Memorandum

To: Bob Gaudreau
From: Mike Nugent/Manager of Inspection Services
Date: 12/08/2004
Re: Building # 7 1039 Riverside St. (331 A001)

I have commenced the review of the remainder of the building plans and require the following information from your design team prior to allowing the next phase of construction:

Title
ELEVATIONS

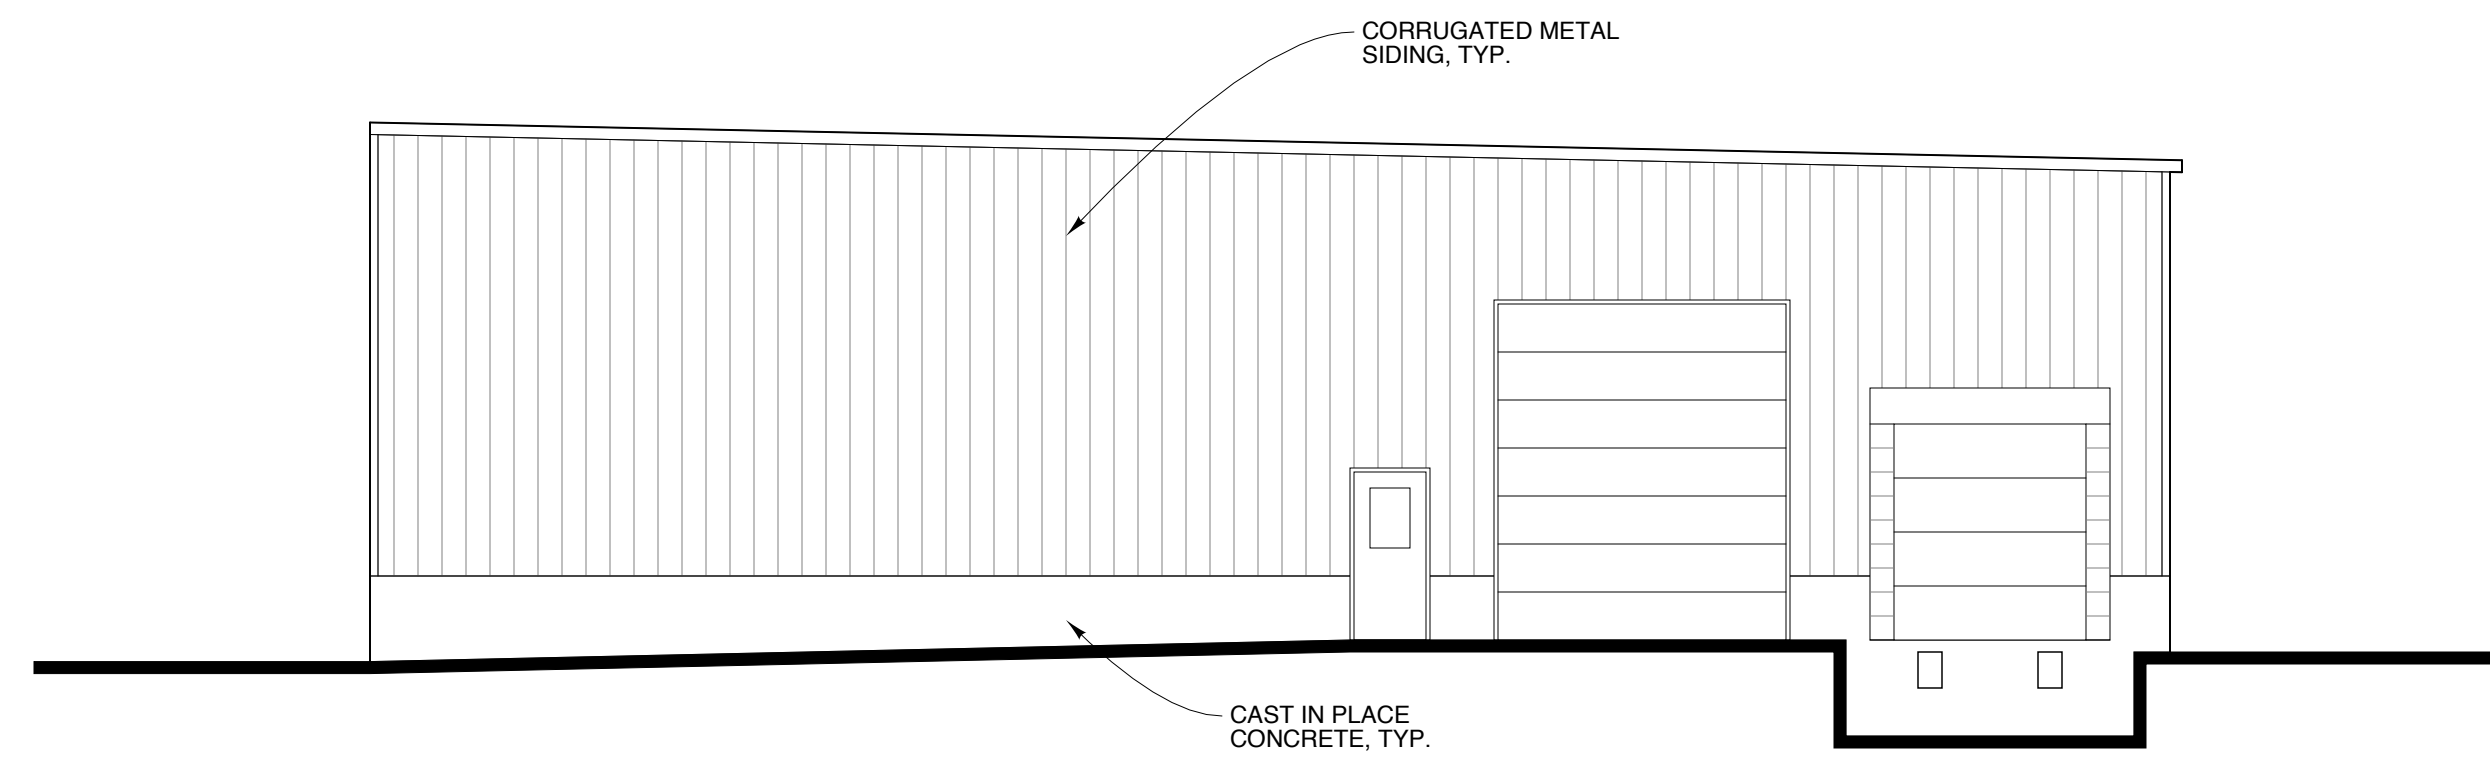
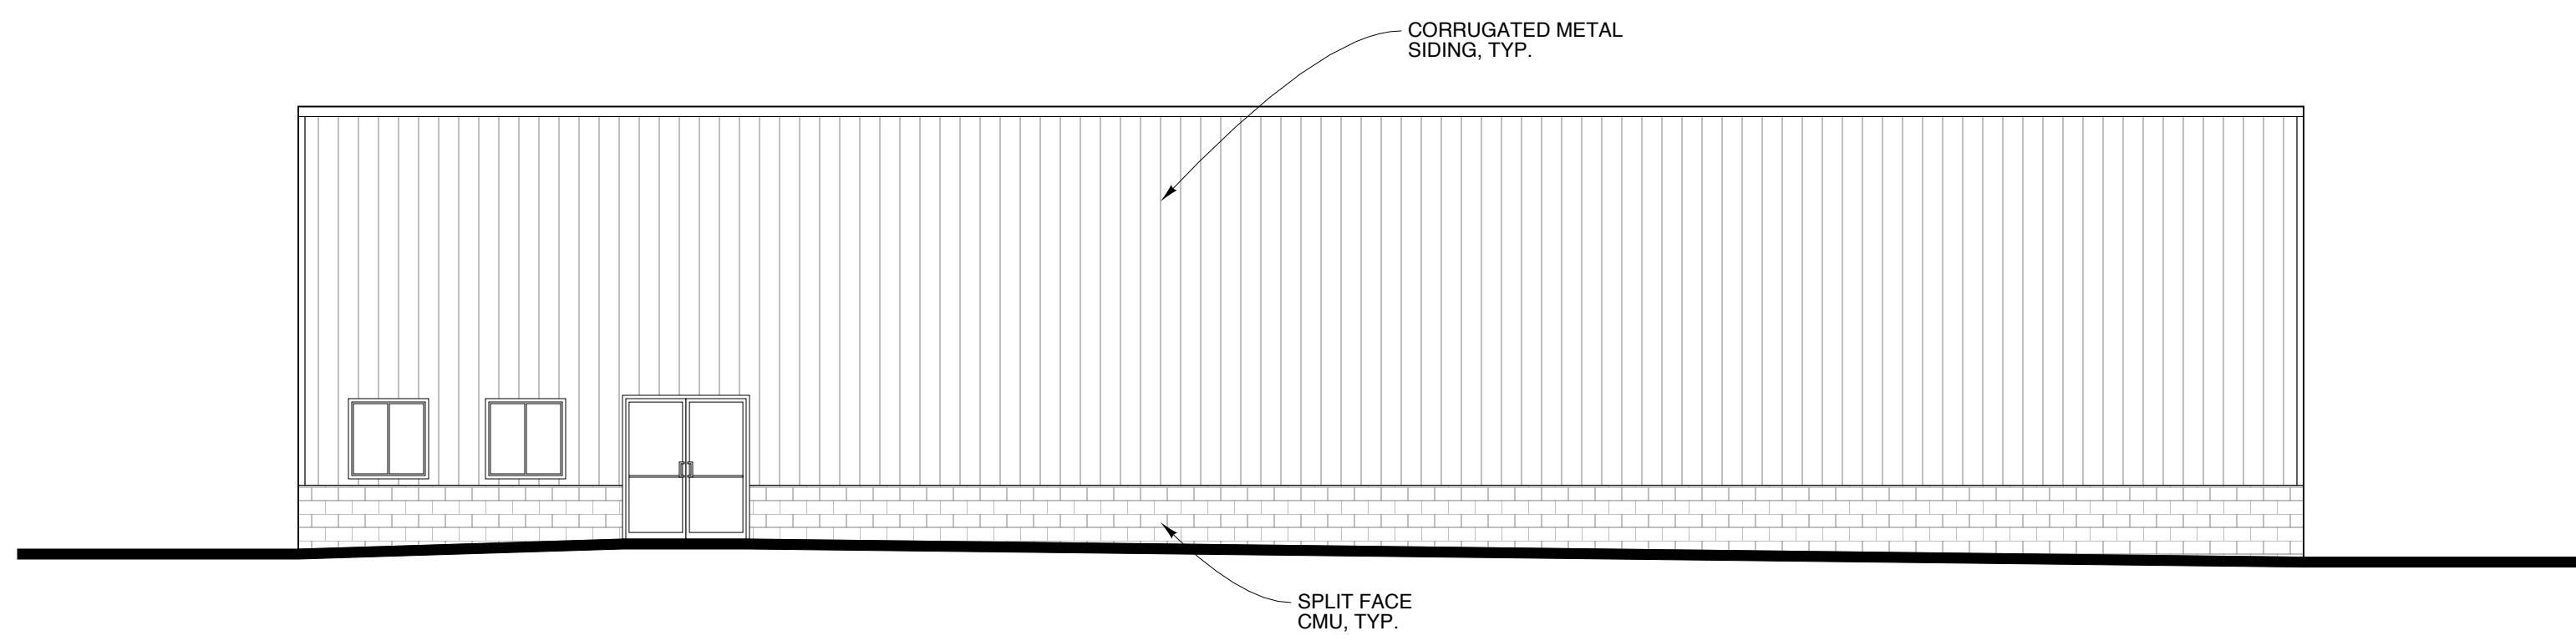
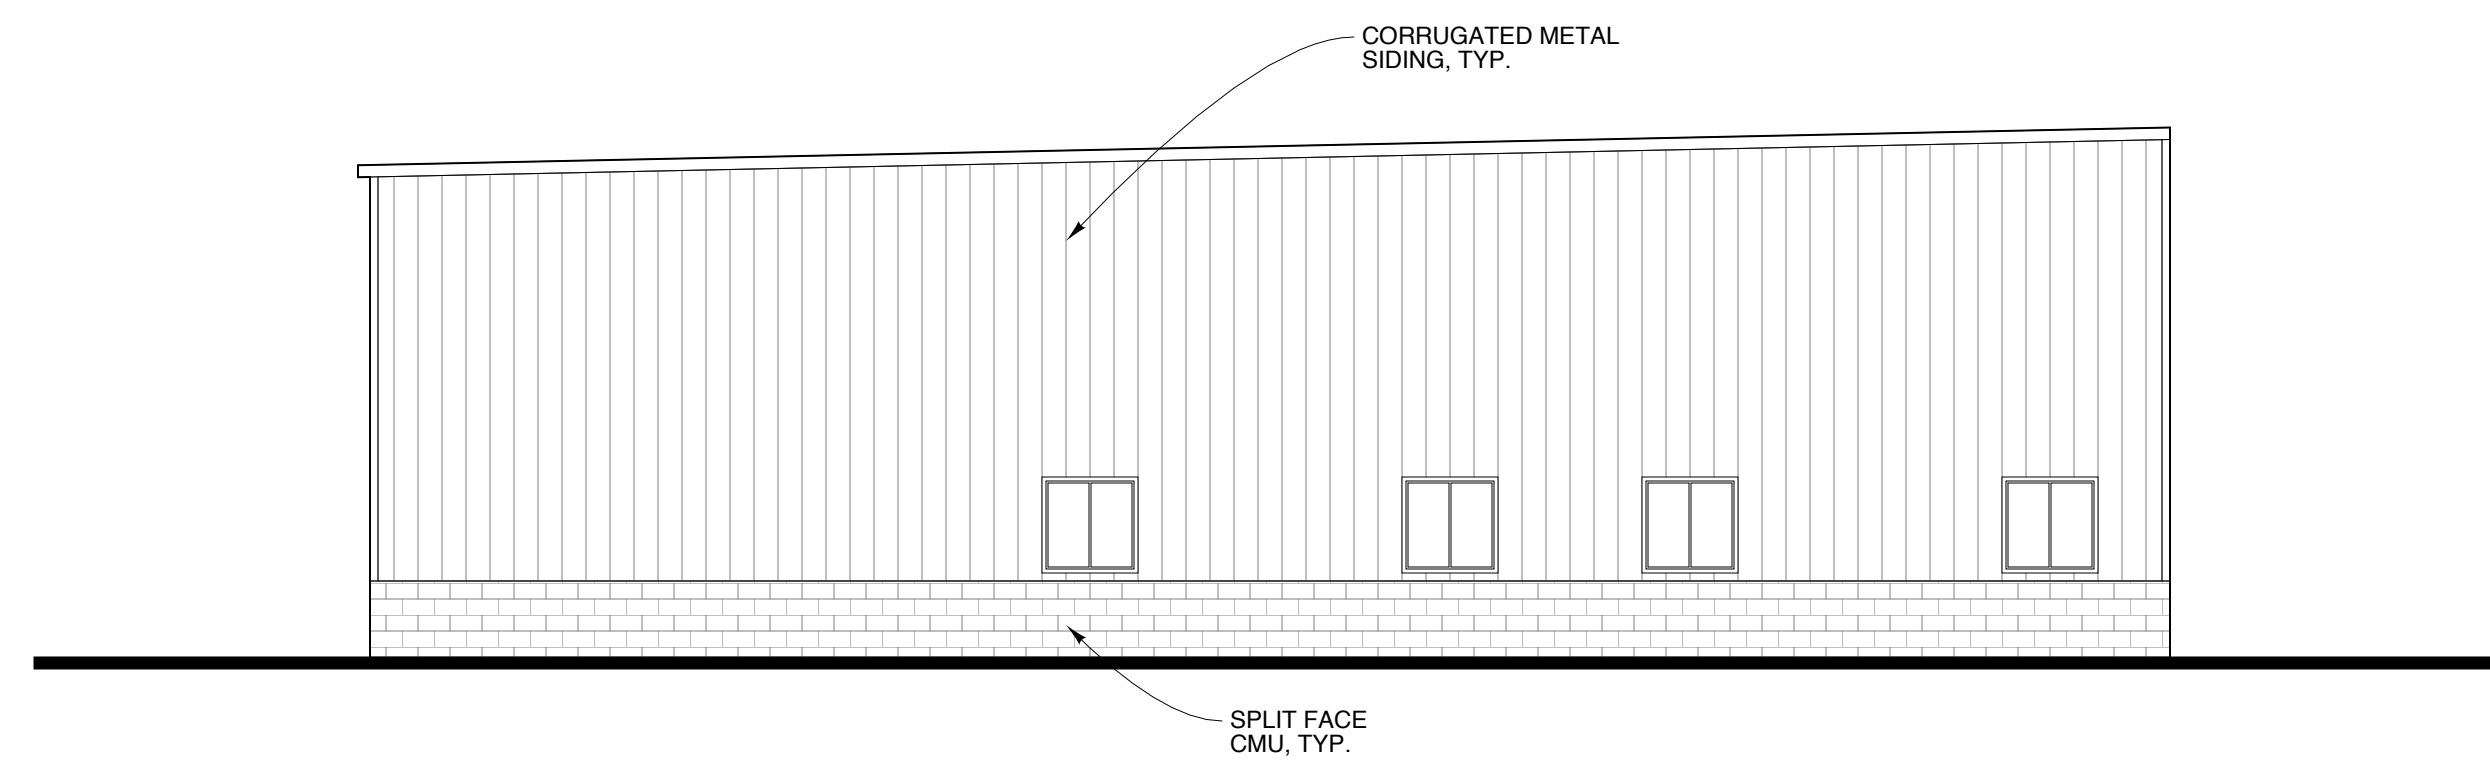
- 4) Need elevations to determine if the entrances will need stairs (based on the site plan there is a 2 foot to four foot difference between grade and the FFE. Need structural details of the stairs and or ramps w/ tread , riser, guard and width details. Any exterior stairway must be protected from the accumulation of Ice and Snow.

2 WALL SECTION
SCALE: 3/4" = 1'-0"
4' 8' 1'-4 2'-8"

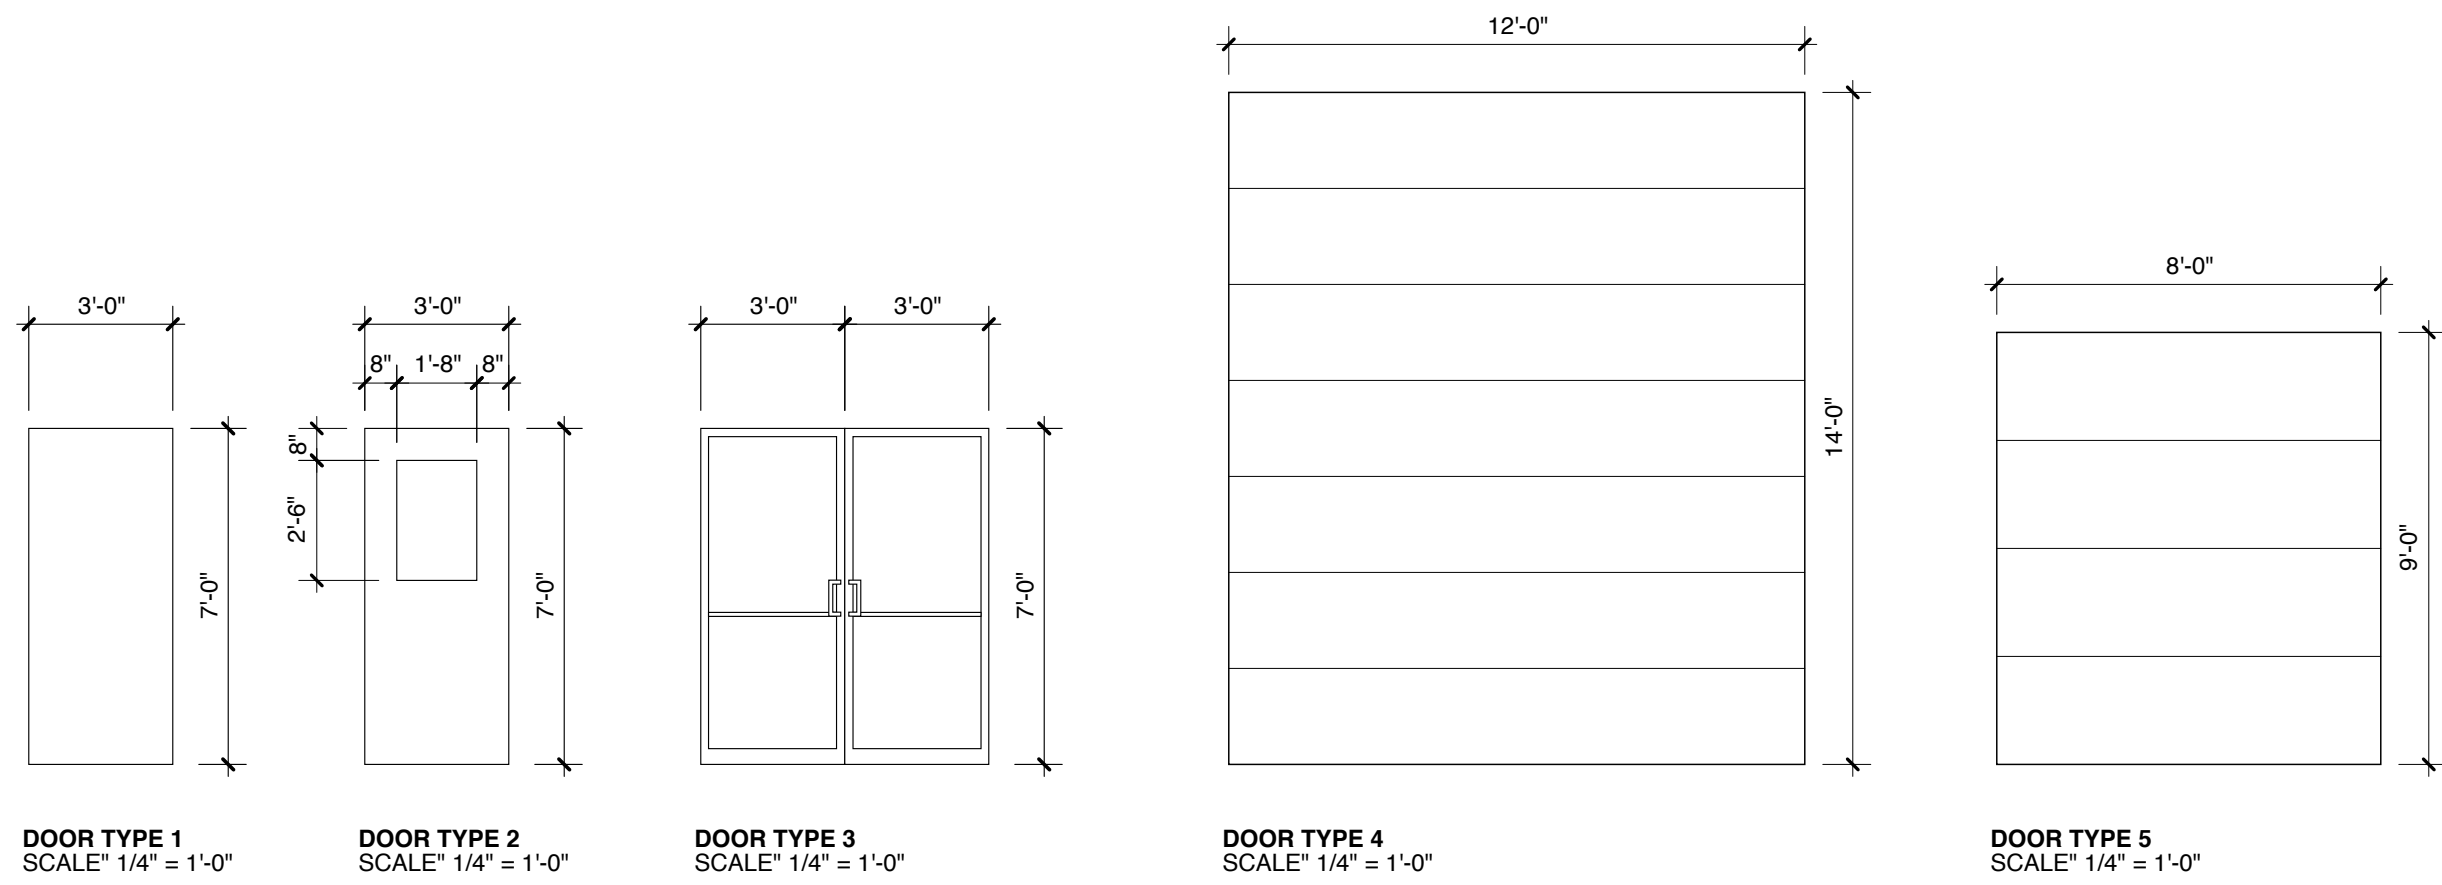
- 1) The "Kirby" plans are not stamped.
- 2) Need a cross section of the fire separation assembly w/ UL listing
- 3) Need a Fire glazing detail w/ ASTM testing standard.
